To the Examining Authority.
Written Submission Deadline 8.

Reference: EA1N. IP: 20024031. / AFP 132
EA2. IP: 20024032. / AFP 0134.

1. Comments on Outline Code of Construction Practice .(REP7-026).
2. Comments on Issue Specific Hearing 12 (Noise).
Figure 1. Email concerning purported baseline acoustic tests at 1 Ness House Cottage.
Figure 2. Aerial Photograph showing location of purported acoustic equipment at 1 Ness House Cottages.

1. Comments on the Outline Code of Construction Practice Rev 4 (REP7-026).

Figure 1 Potential Sensitive Receptors and Areas Subject to Additional Construction Phase Controls

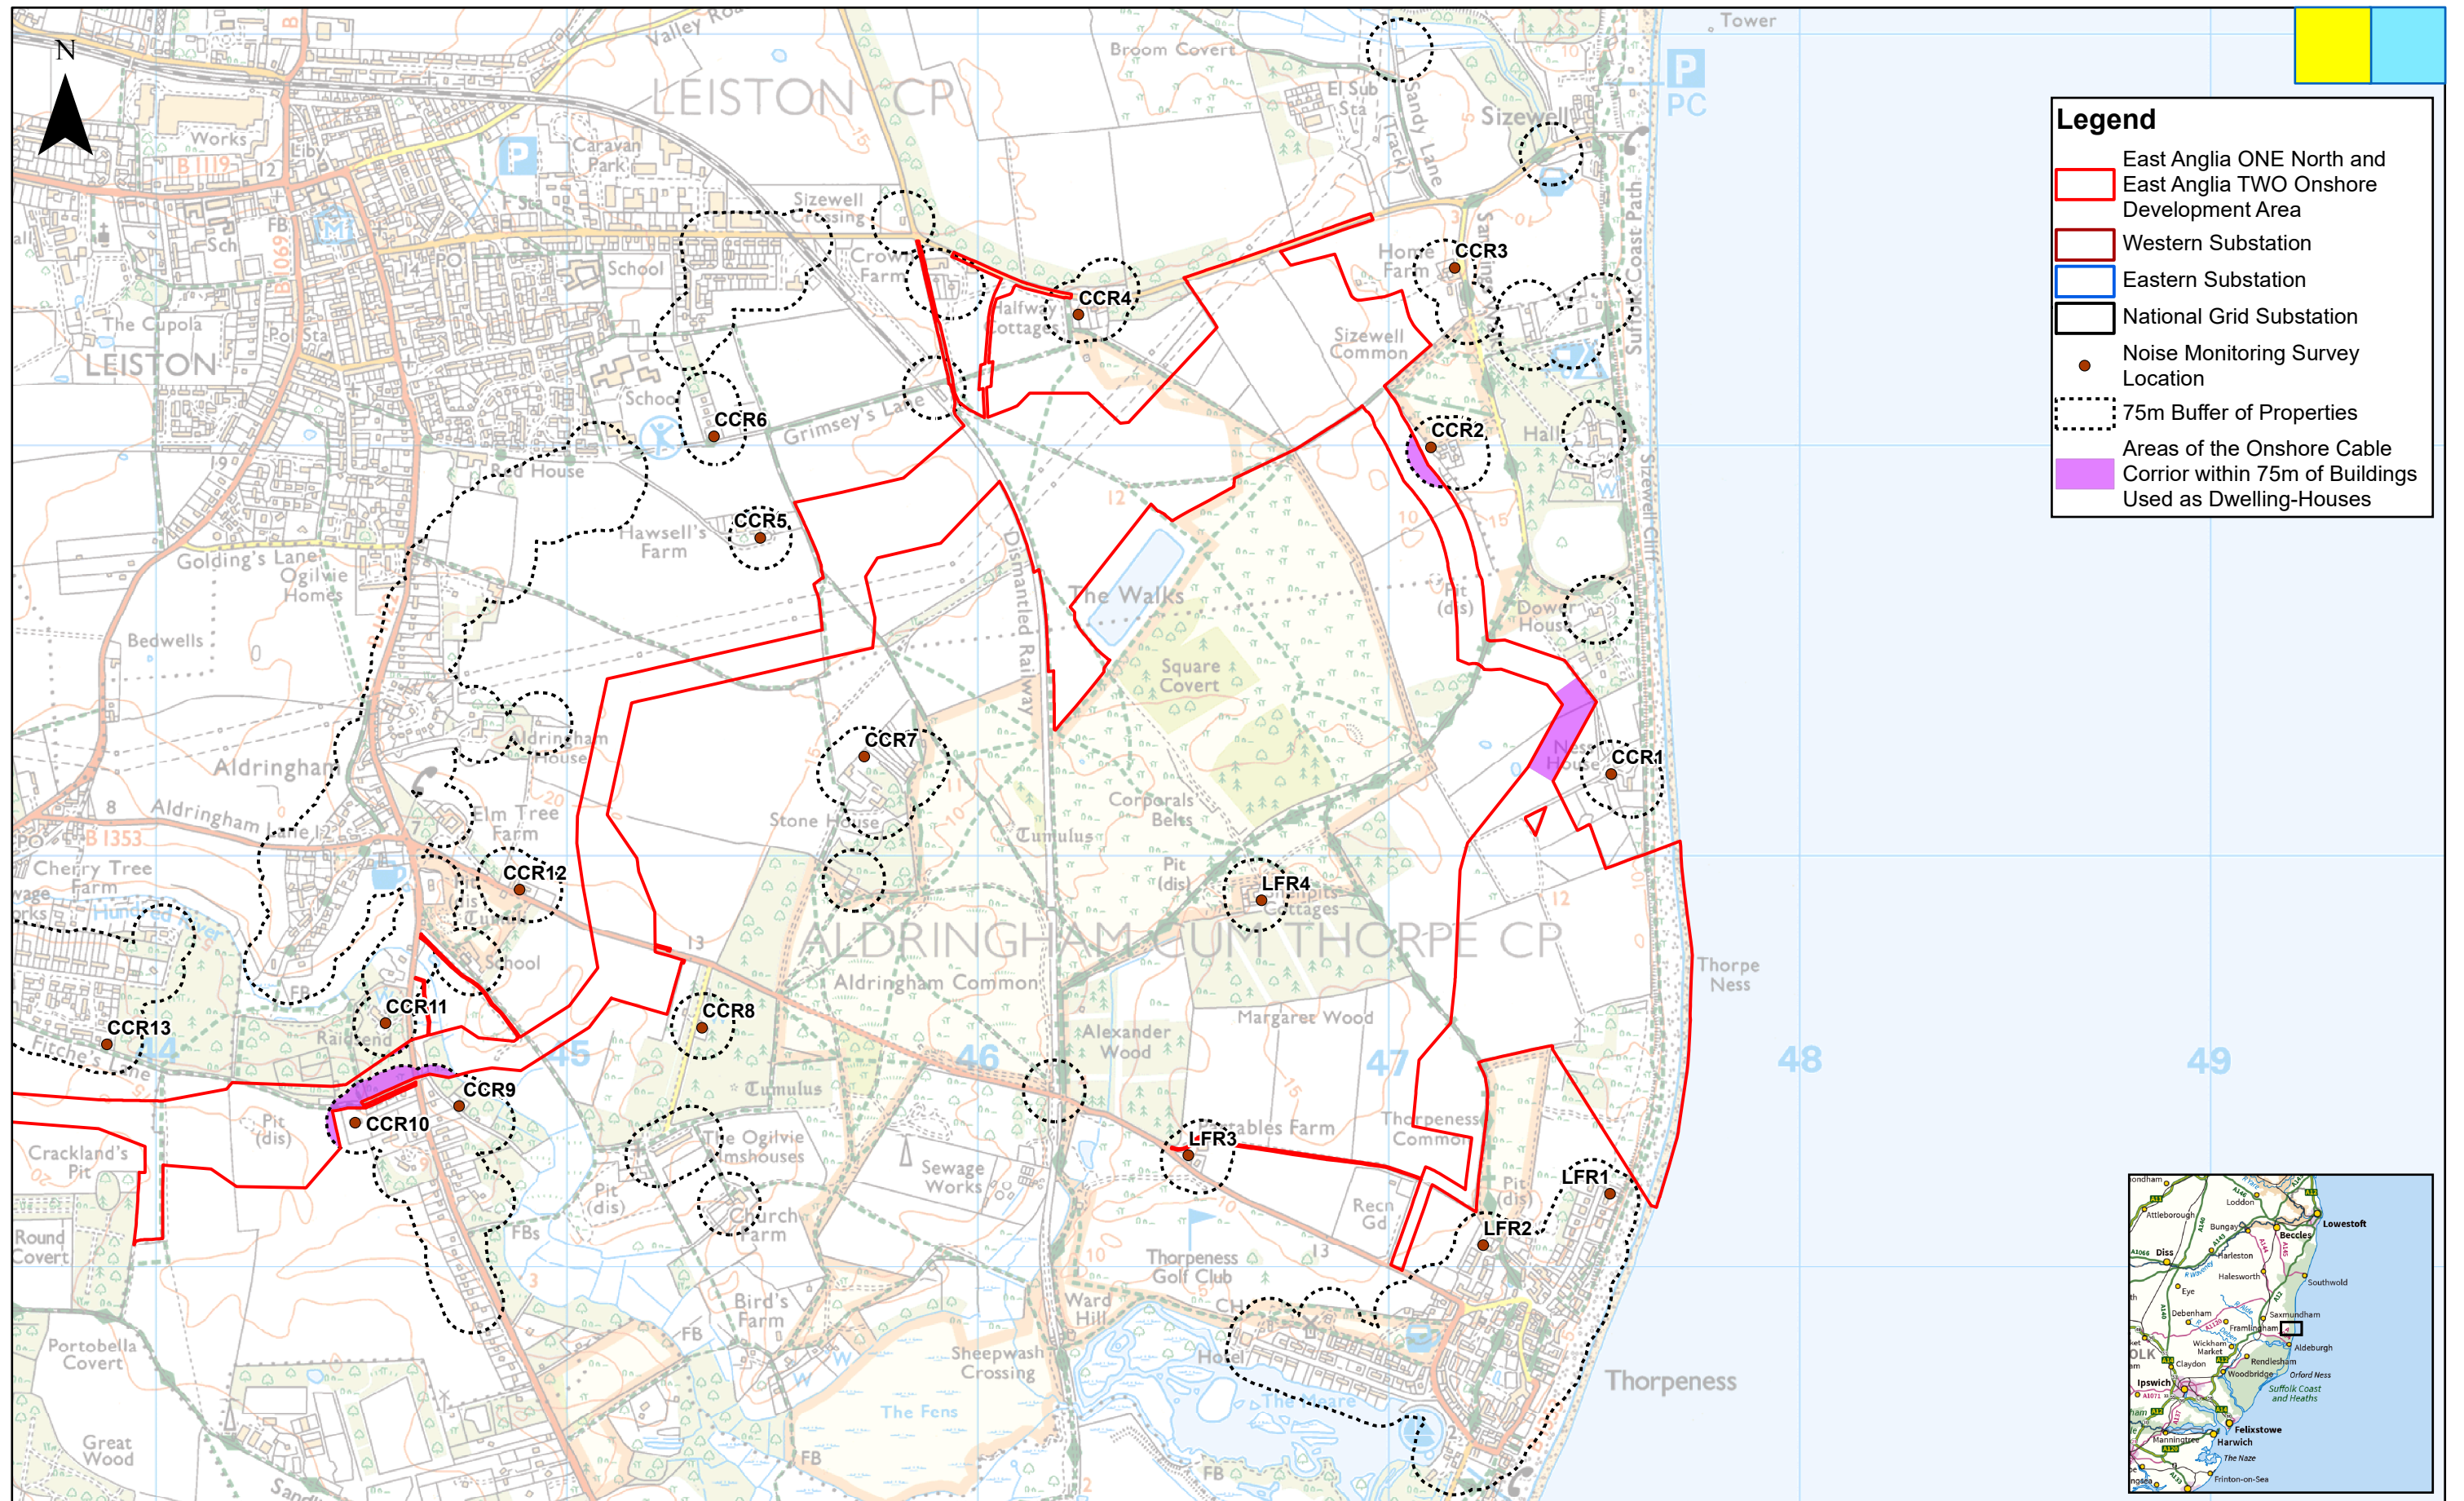
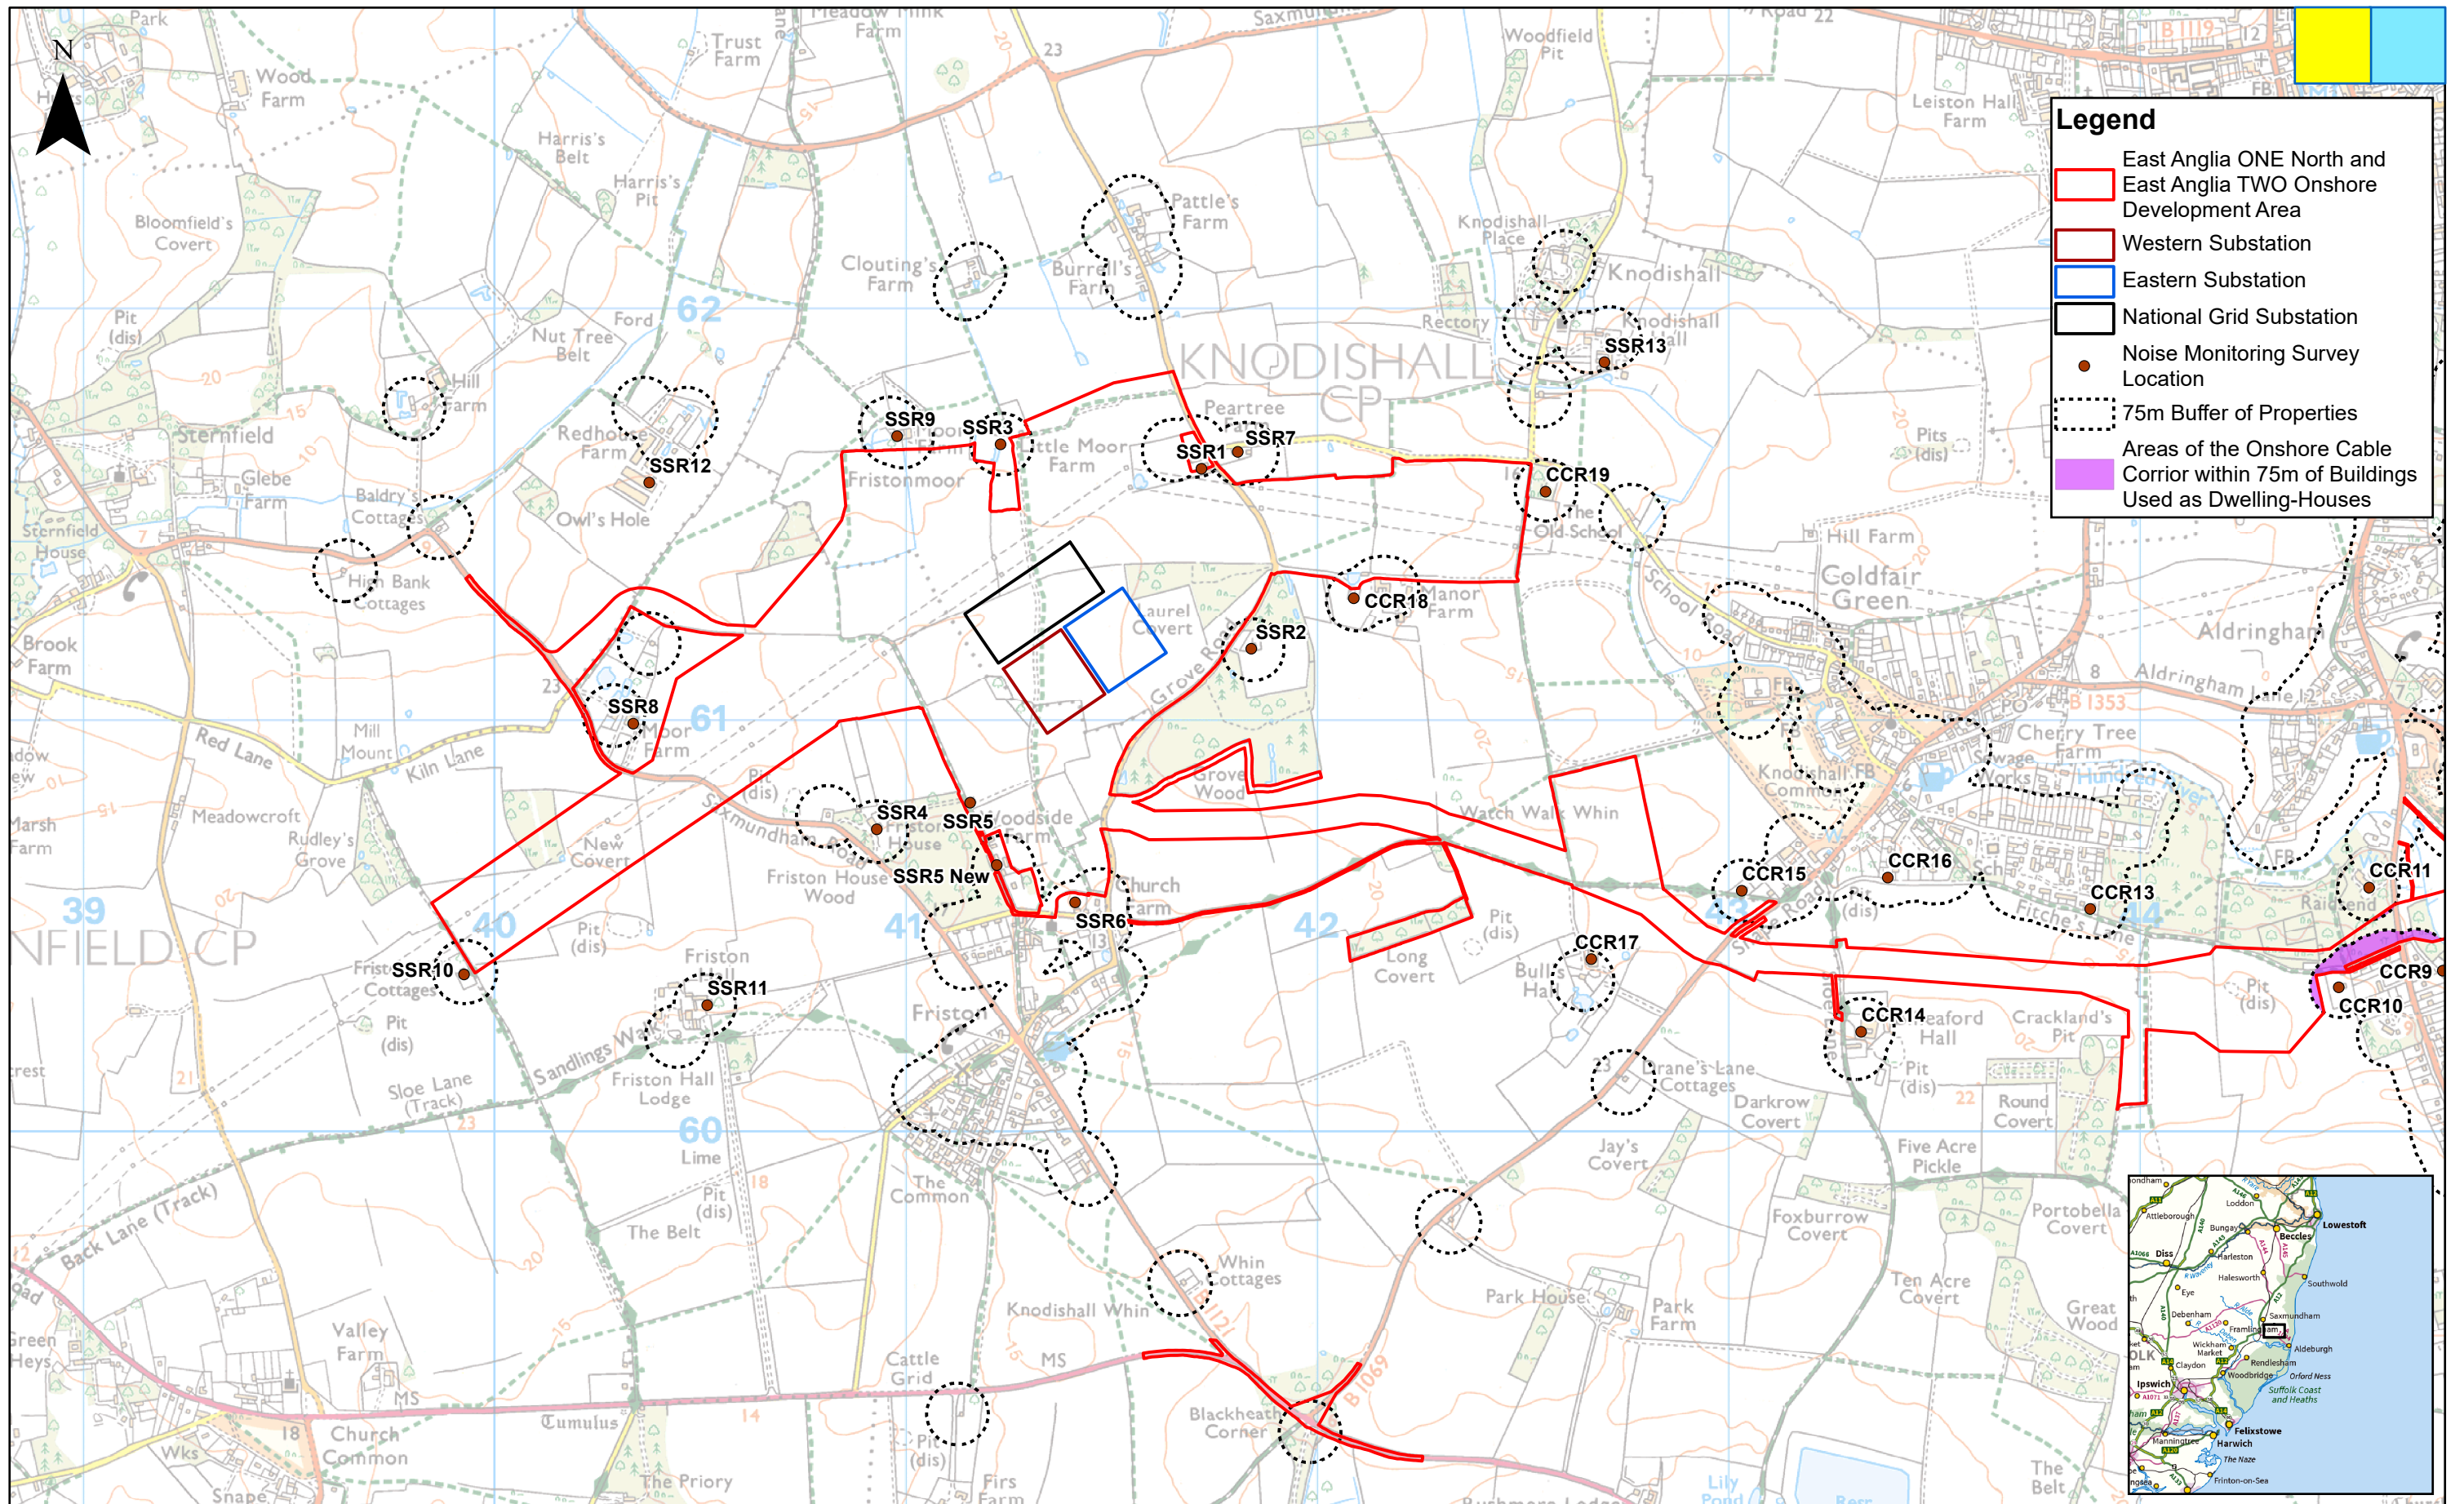
In my Deadline 1 WR, I drew the Examining Authority's attention to the inaccurate identification of a Noise Monitoring Survey Location directly westward of the garden gate of 1 Ness House Cottages, identified on the map referenced above as CCR1. This point was also raised by Richard Reeves at ISH 4 Day 2.

An aerial photo was attached showing clearly that the monitors would be sited directly at the bottom of our garden, with a picture of the monitors in question. These are the monitors identified as CCR 1 in Appendix 2, Figure 1. In fact, as the Baseline Noise Monitoring Tables show (APP-524) they are identified with another property at a different location, Courtyard Cottage

In the Applicants Environmental Statement APP-524 6.3.25.3 Table A25.3.4 Baseline Noise Monitoring Locations Onshore Cable Route Study Area, [REDACTED] and [REDACTED] are the only 2 properties cited as the location of noise receptors. [REDACTED] is identified as the address closest to CRR1 on that Table. The period of monitoring is identified as being on 3/ 7/2018 from 13.08.40 to 13.36.40) .

[REDACTED] are significantly further away from the construction site, and one of them is a holiday let and not permanently inhabited. This failure to provide correct information and identify different properties means that our households, at a distance of one modest sized field from the proposed Landfall and encircled by cable corridor works, set down etc, have been excluded from Baseline Noise Monitoring information provided to the ExA, except for a period of half an hour, and there are no studies pertaining to the impact upon them of the works, vehicle and personnel movement. Can the Applicant explain why? “

Despite this point being raised on both these occasions, and the significance of Wardens Trust having become more visible in recent weeks, the Applicant has not amended or corrected the information in the important OCoCP. It's a detail but does show a relaxed approach to the accuracy of the documentation which they are placing before the ExA and on public record.
